EPC STORMWATER REVIEW COMMENTS
IN ORANGE BOXES WITH BLACK TEXT

UDON SOUTH GRADING & EROSION CONTROL PLANS

UDON SOUTH
GRADING AND EROSION CONTROL PLANS
EL PASO COUNTY, COLORADO
COVER SHEET

**UDON SOUTH  
 GRADING AND EROSION CONTROL PLANS  
 EL PASO COUNTY, COLORADO  
 INITIAL PLAN**

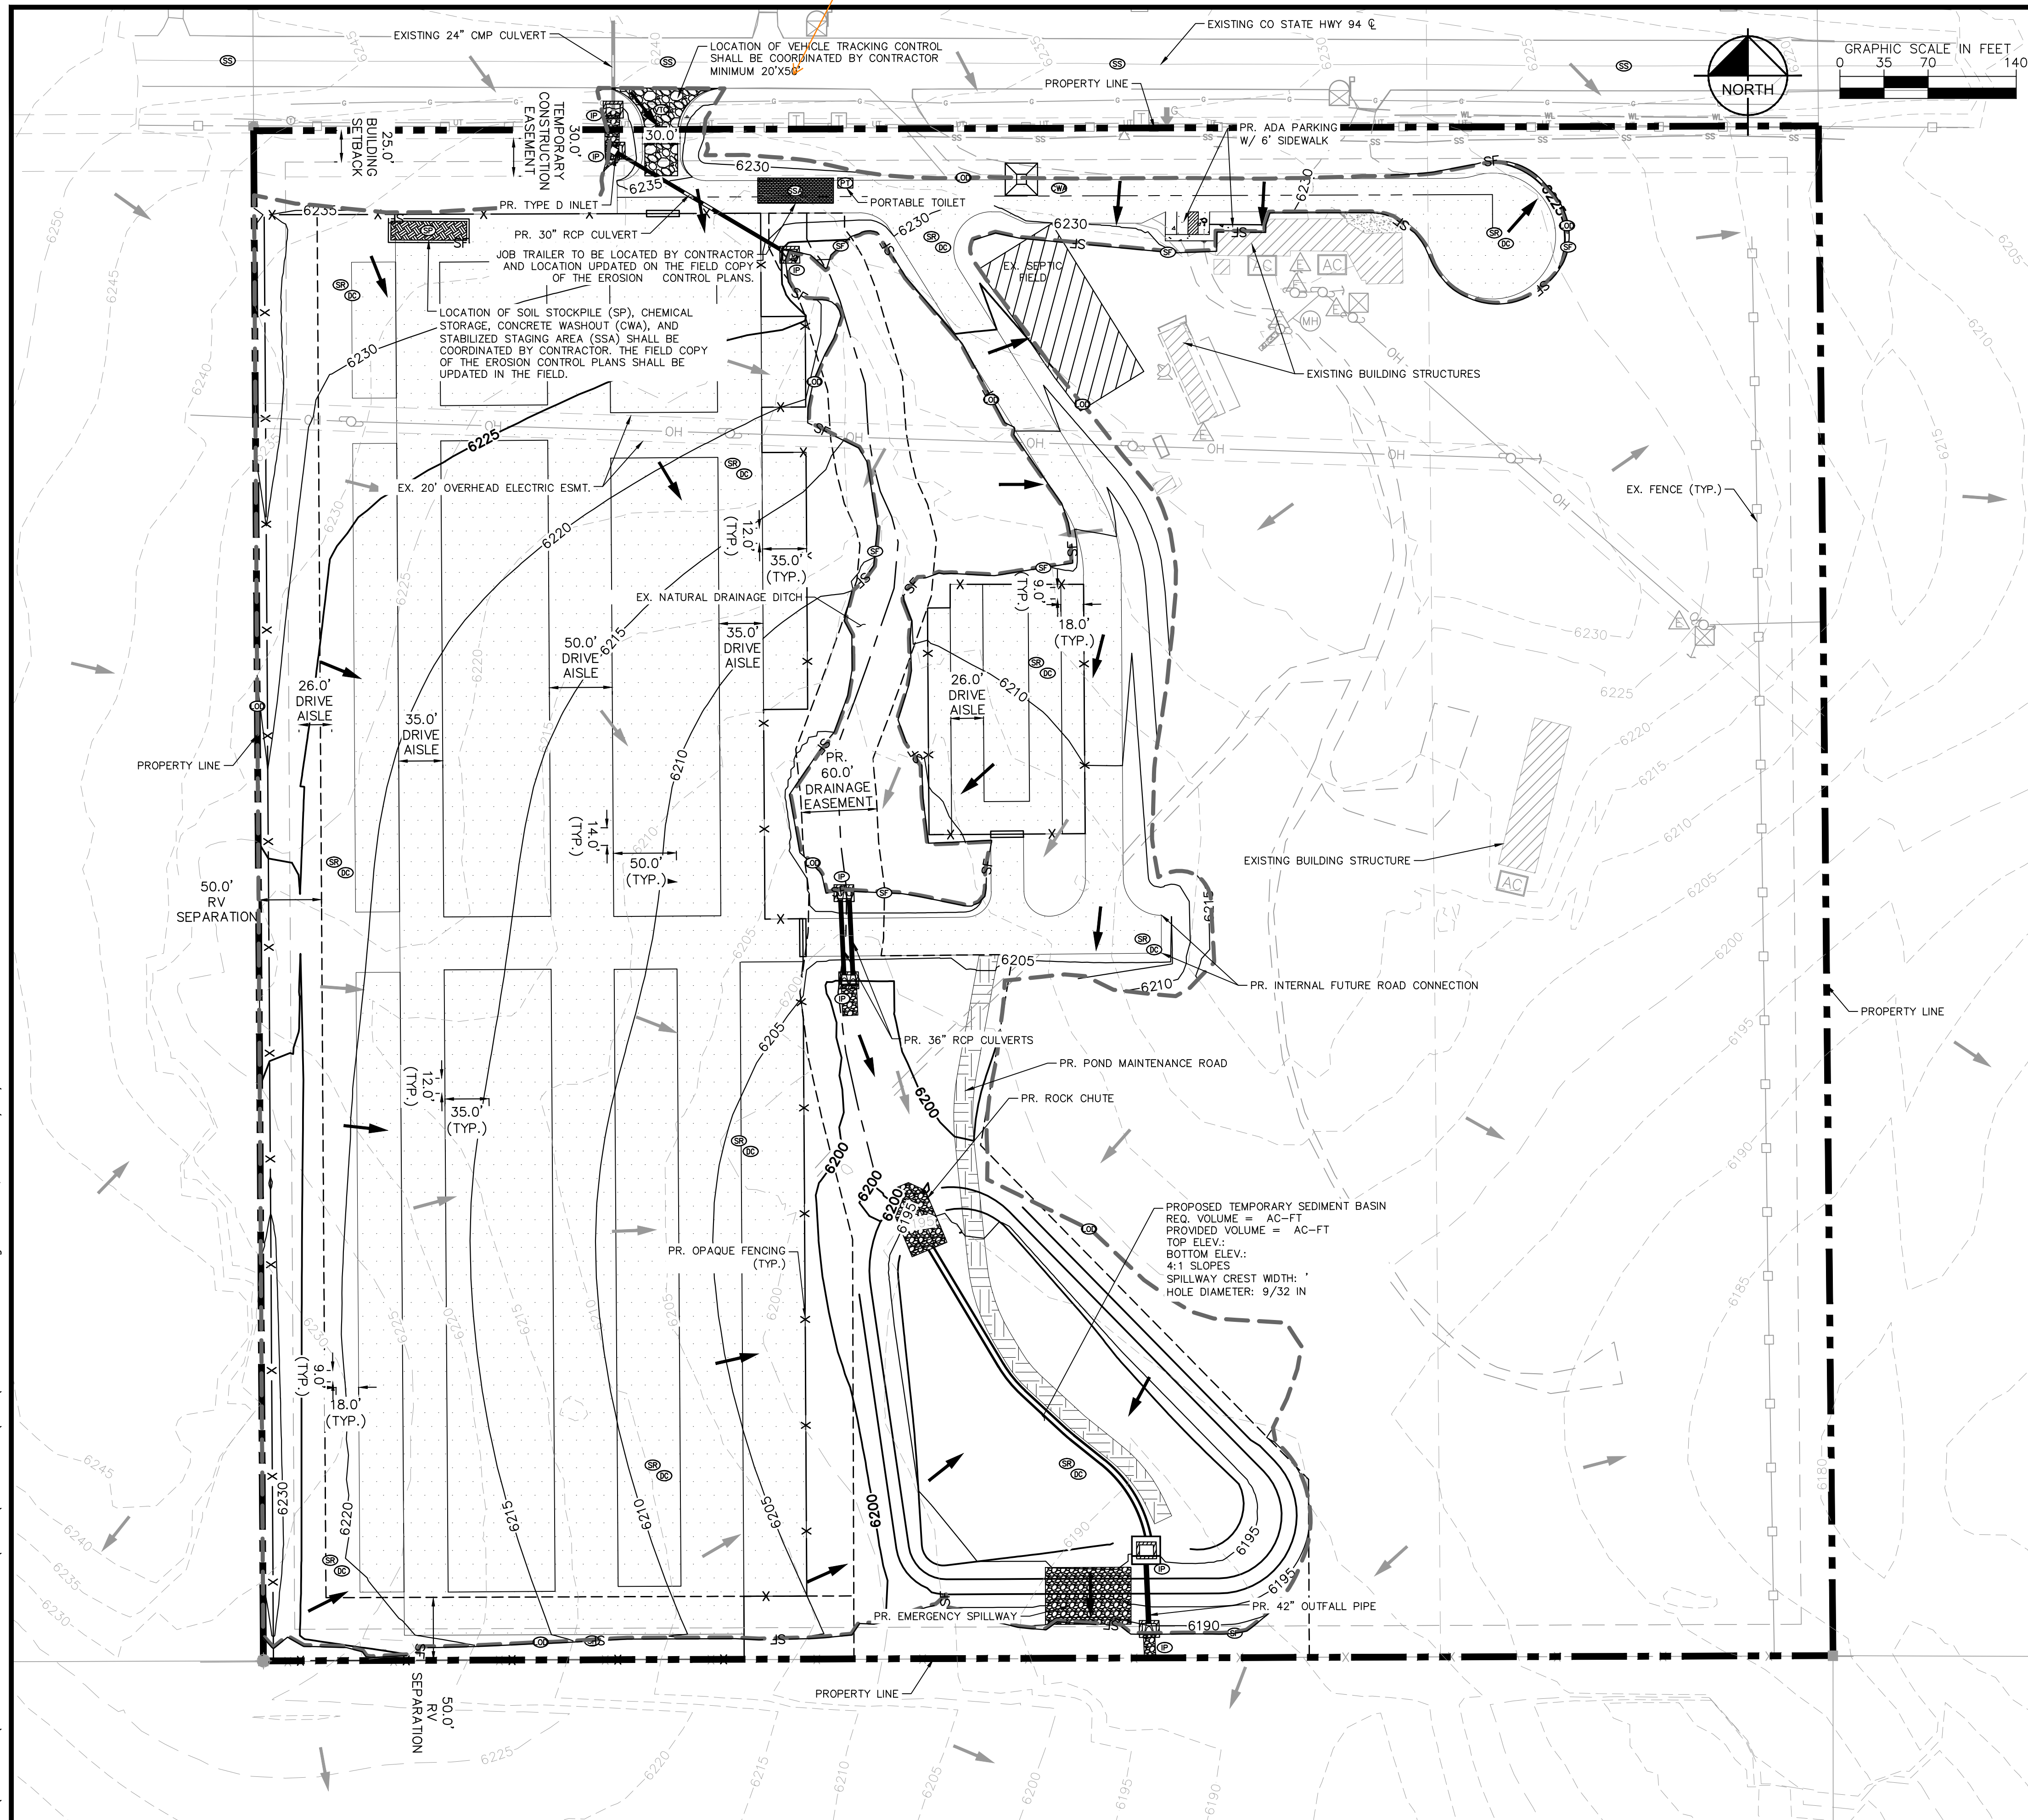
Unresolved: GEC Checklist Item i - Show existing vegetation or provide note describing vegetation on site.
